West Oxfordshire District Council

Response to Botley West Solar Farm Statutory Consultation

February 2024

Legend

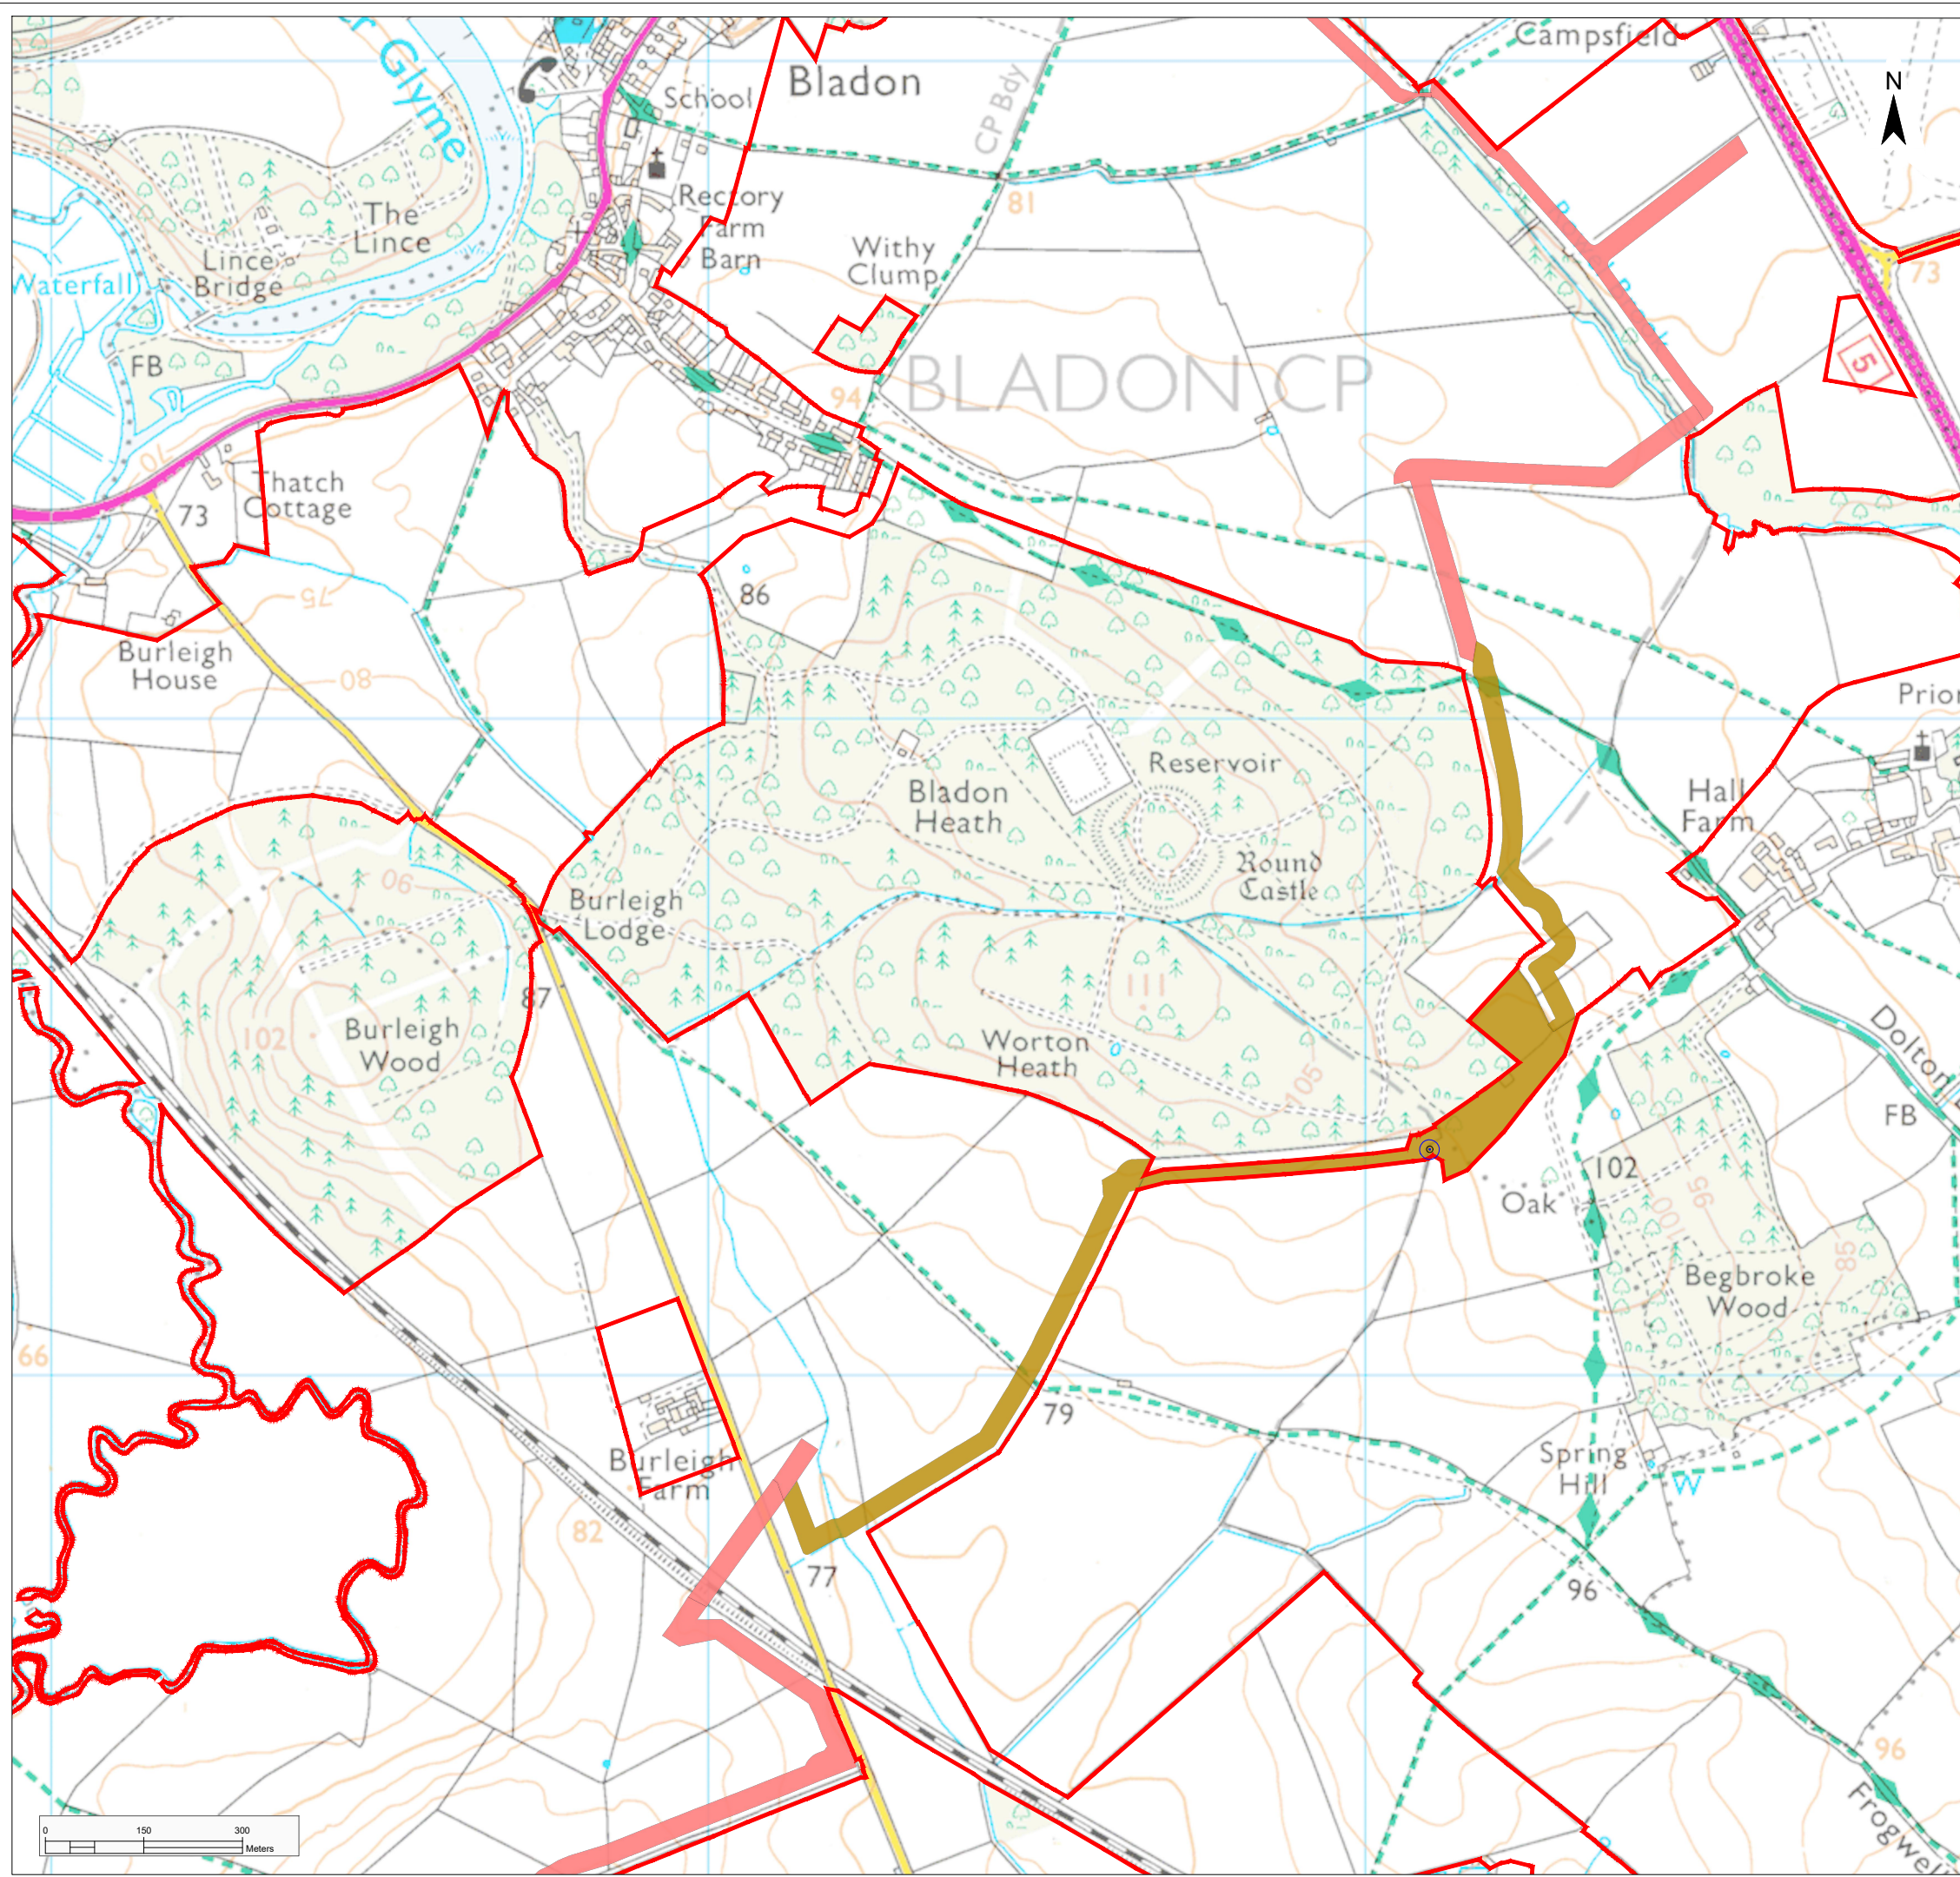
- 4.20 **WODC suggest that removal of development areas from the visually exposed and prominent valley sides to the west of Lower Road and valley sides of the River Evenlode could minimise negative impacts of the proposal. This will reduce potential for negative landscape character impacts by restricting development in visually prominent and exposed locations and minimise impacts on the setting of Church Hanborough Conservation Area.**

- 4.21 **WODC also suggest that development be restricted from land to the north of Cassington. Although the masterplan indicates that development would be set back from the edge of the settlement in this location, land rises steeply to the north of the settlement making any development in this location prominent and visually exposed. This area is also within the Green Belt, which performs particularly well in this location in terms of protecting the historic character of settlements and safeguarding the countryside from encroachment.**

- 4.22 **It is noted from the masterplan that there is a proposed buffer zone to the south of Bladon to mitigate against potential landscape and visual impacts. There are a number of key sensitivities in this location including proximity of residential properties, proximity to the Bladon Conservation Area and the setting of the Blenheim World Heritage Site. WODC consider that the proposed buffer area should be substantially increased to minimise impacts on sensitive receptors in this location.**

- 4.23 **Proposed buffers adjacent to Ancient Woodlands and Public Rights of Way should be increased in this area to reduce impacts on the PROW network and provide opportunities for further woodland creation. The applicant is proposing a 15m buffer around Ancient Woodlands in accordance with Natural England guidance. WODC understand that proposed buffer distances are designed to protect the root structure of trees rather than protecting the visual importance and sensitivity in the landscape of those woodlands and presenting real enhancement opportunities. Opportunities should be sought to increase woodland cover in the area where possible. There are two public rights of way along the eastern side of Bladon Heath. Stepping development away from these would mitigate the impacts on sensitive users of the public rights of way network**
